Application No: BR/197/25/PD

Site Address: Allestree Court Walton Road Bognor Regis PO21 1NN

Description of works: Application for prior approval under Schedule 2 Part 20 Class A for the construction of one additional storey creating 2 No. additional dwellings.

Thank you for your internet representation made on 27th November 2025 which has been recorded as an objection with the comments as follows:

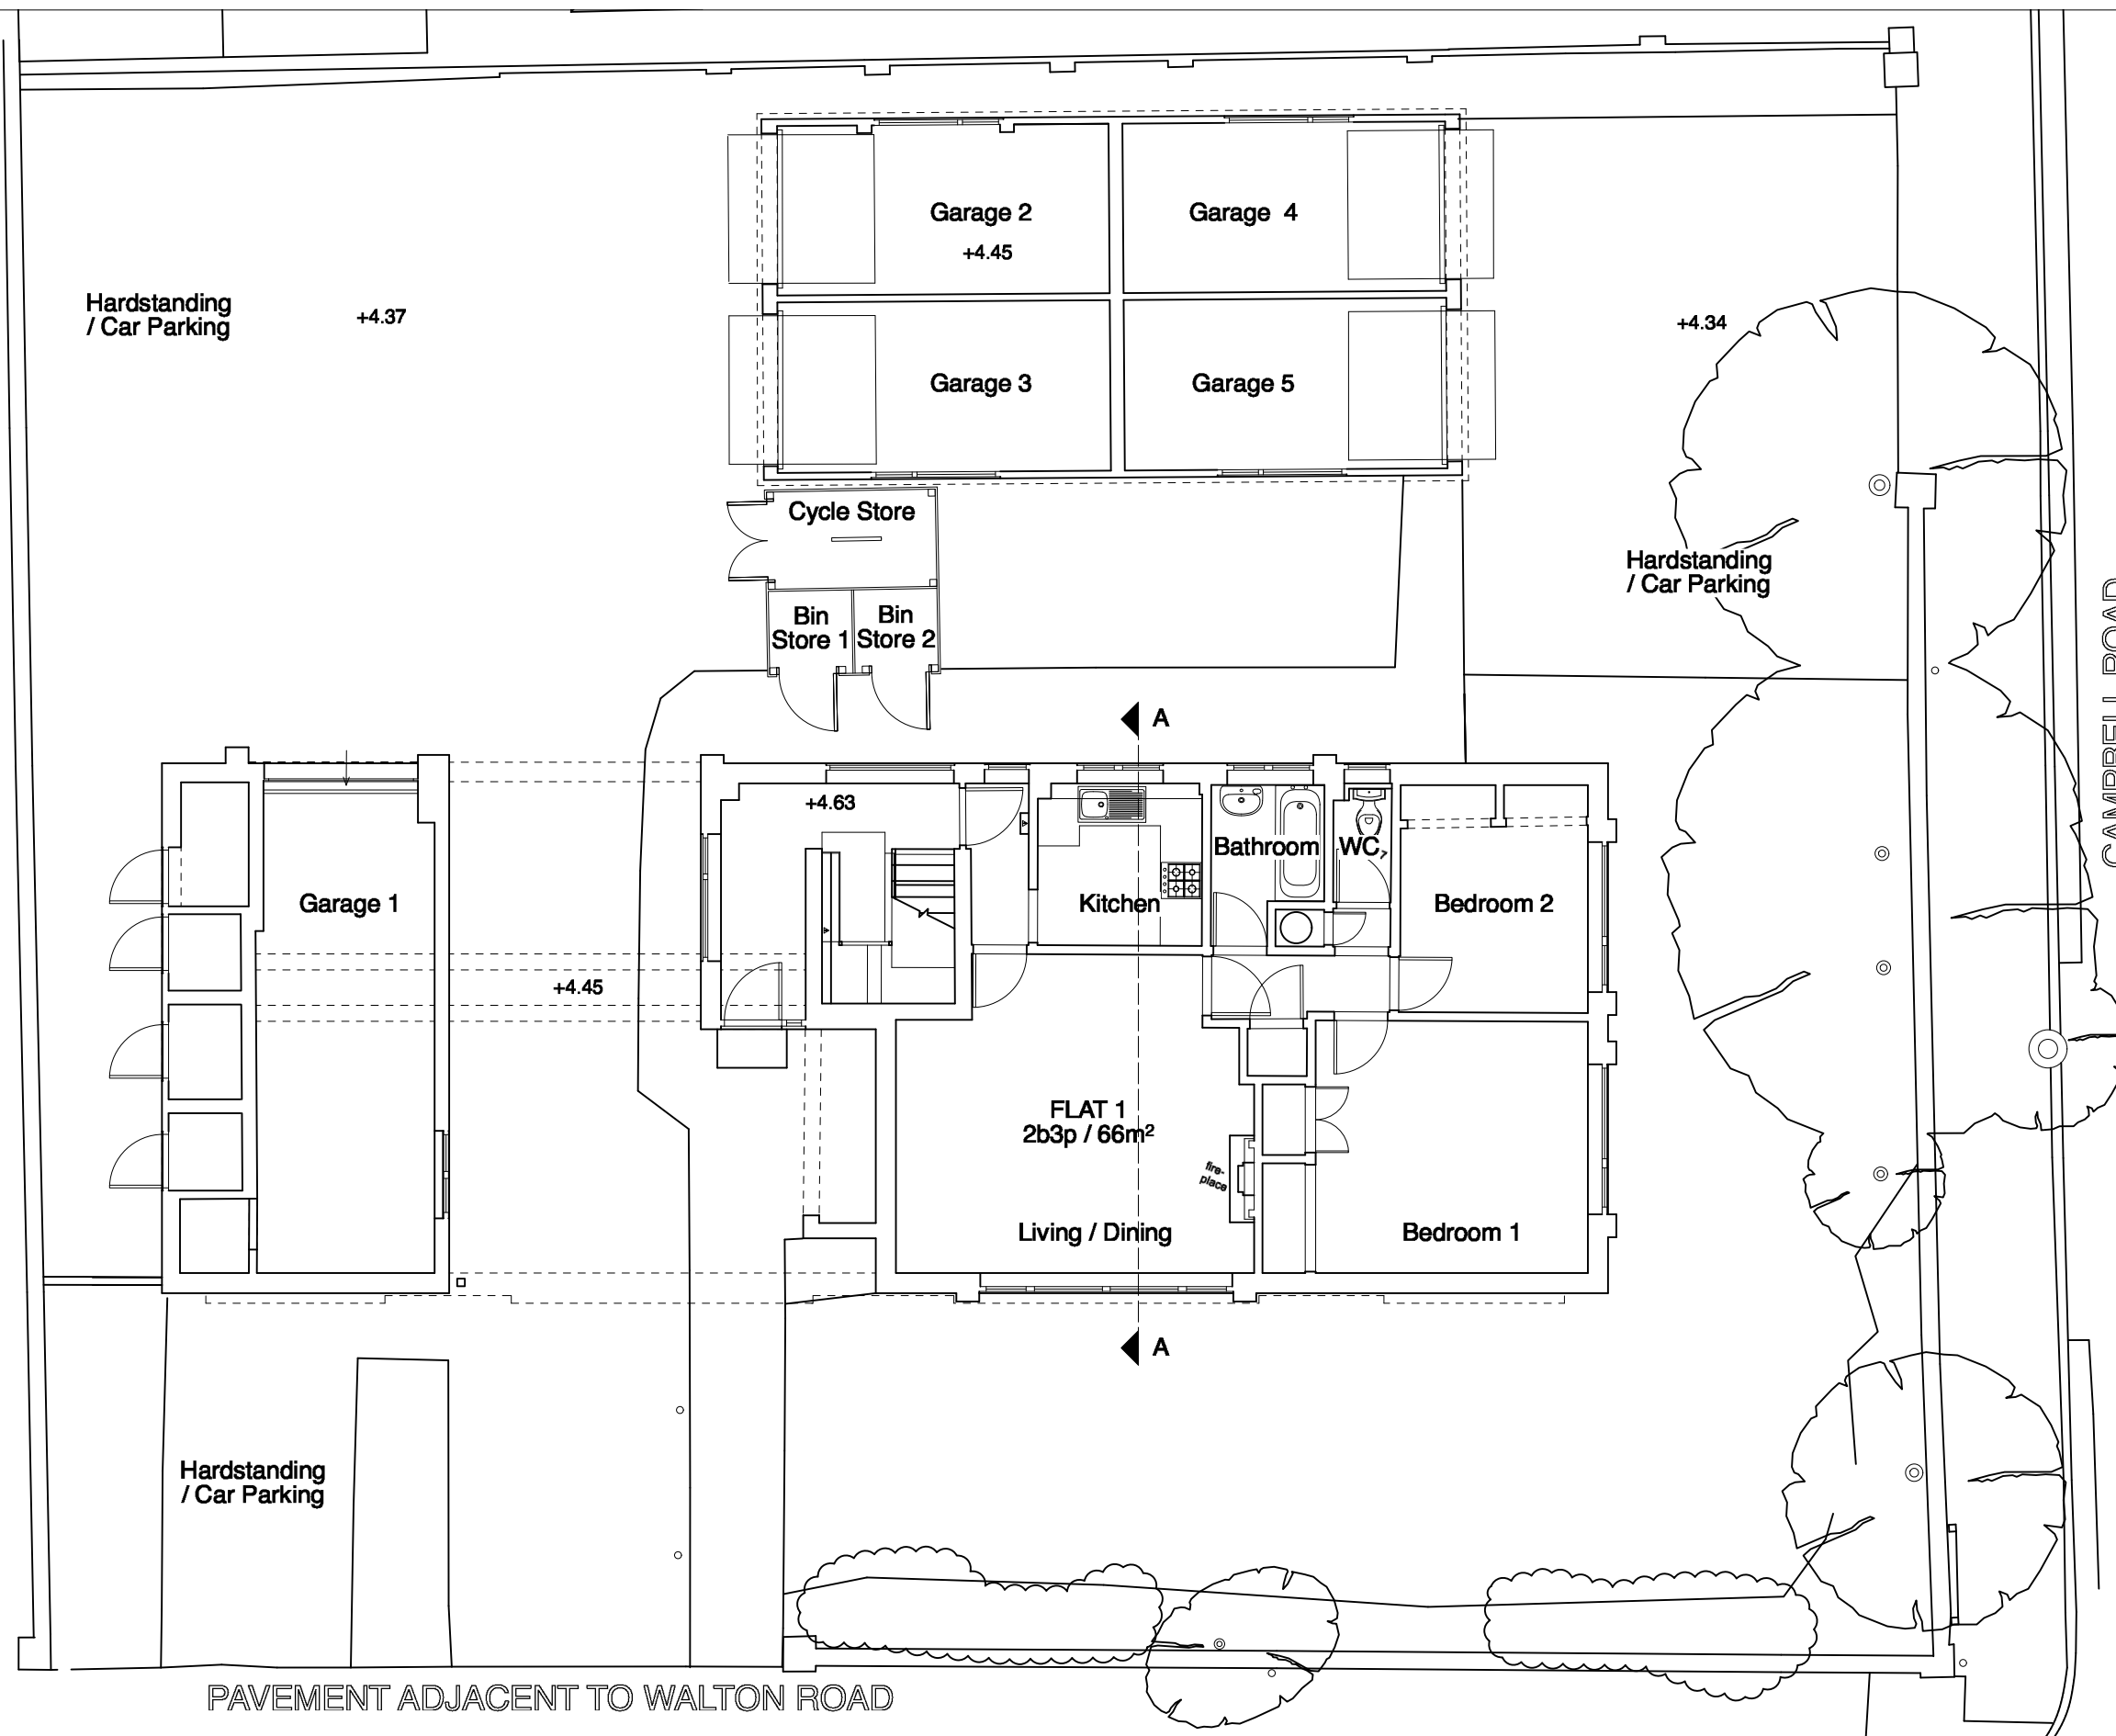
1. The proposed parking arrangements will not be sufficient for any more flats. The occupants of some of the existing flats have more than one car and it is highly likely that occupants of any new flats may also have more than one car and will be given the expectation they can park "off-road". The plan suggests marking out spaces for each flat, but this will not help. None of the current occupiers use their garages to store their cars because their cars are too big to fit inside them, therefore they park in the accessway in front of the garages.

It is currently impossible for anyone to use their garage for its intended purpose because there is no room to manoeuvre around other people's cars. Some occupiers will therefore have to park in the road, which will add to congestion and pollution.

PROPOSED THIRD FLOOR

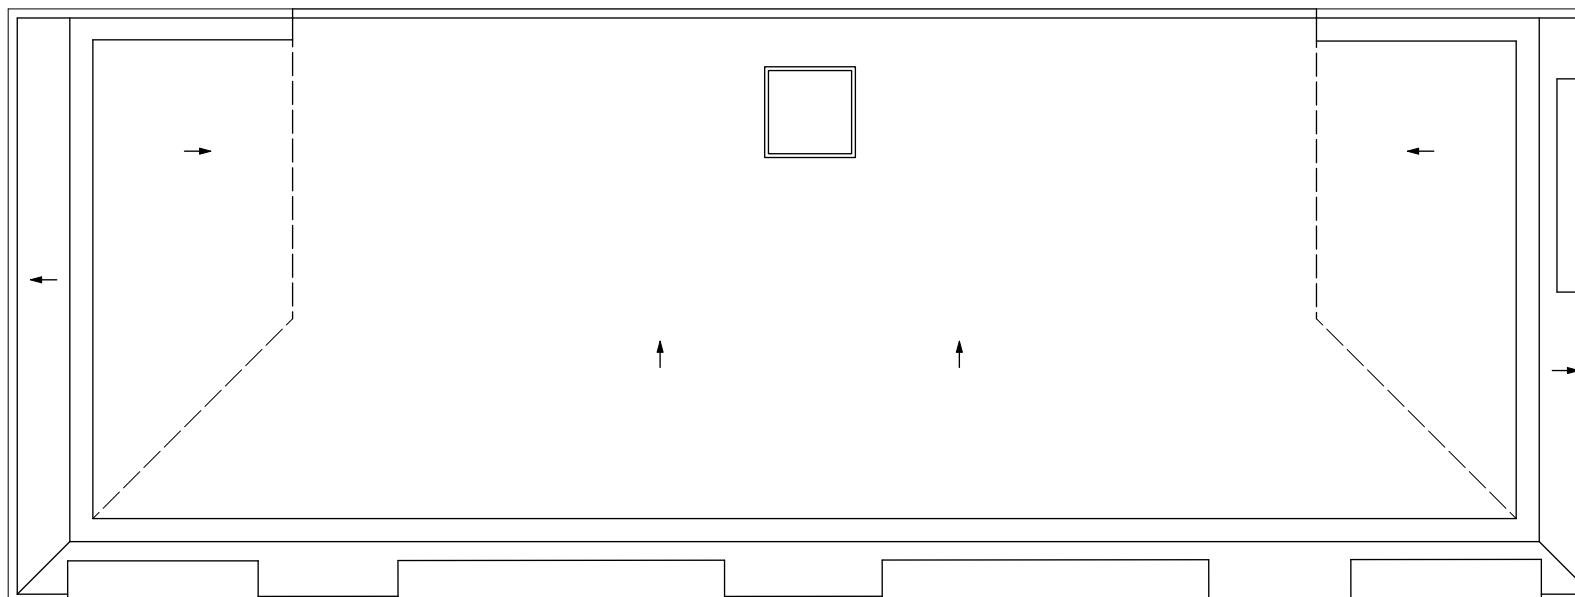
2. Having an additional flat above my own will result in increased noise levels which will impact my right to quiet enjoyment of my property as specified in my lease.

3. The existing stairwell and porch/front door area are dark, narrow, outdated and in need of improvement. To extend the staircase further will exacerbate logistical problems for moving furniture in and out of the building, especially as there is no fire escape and there are still no plans to provide one. The proposed extension could be hazardous in the event of an emergency, particularly for those living in the additional storey who would have further to go to reach the only available exit.
